STATUTORY PLANNING CONSULTATION RESPONSE

Application Number:	3/2026/0356
Proposal:	Erection of 77 no dwellings and creation of community parkland, with vehicular access from Whalley Road and associated infrastructure, parking and landscaping.
Location:	Land at Hammond Ground Whalley Road Read BB12 7RP

Lead Local Flood Authority Position

Client		APPLETHWAITE									
Project		PROPOSED RESIDENTIAL DEVELOPMENT WHALLEY ROAD READ									
Title		DRAINAGE STRATEGY									
Drawn	A1	Scale	1:500	Designed	JLE	Checked	LS	Date	MAR 26		
Drawing Status		PRELIMINARY									
Job Number	24028	Originator	PWA	Zone	00	XX	DR	C	1002	Rev	P02

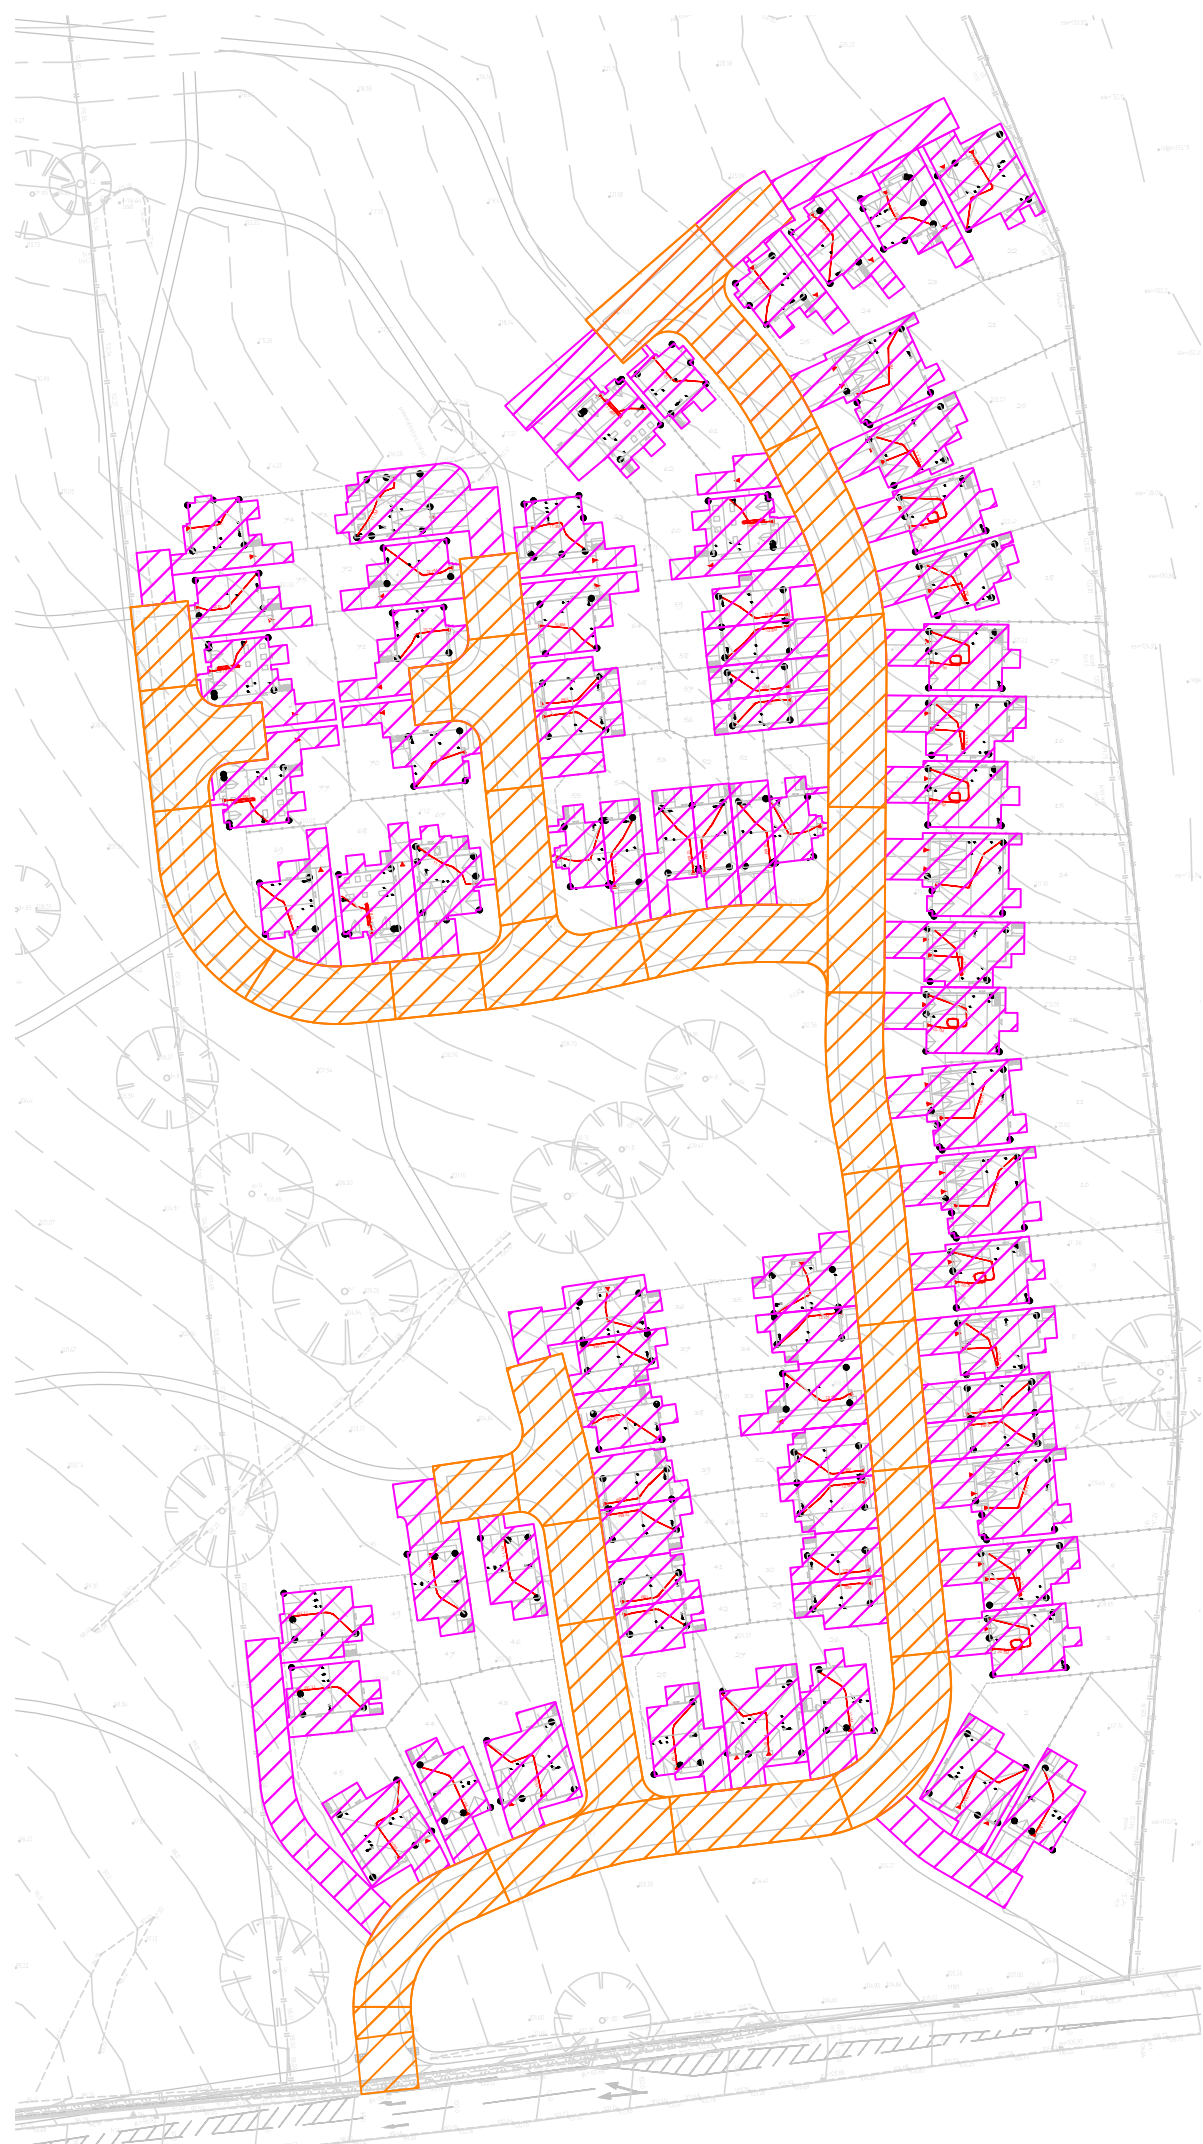
- The applicant is expected to provide some indication as to how surface water from higher land is intended to be managed as this has the potential to have an impact on the proposed drainage and its contributing area or affect the flood risk of the post development scenario.
- The applicant is expected to provide evidence of how the proposed discharge rate has been derived based on appropriate industry standards.
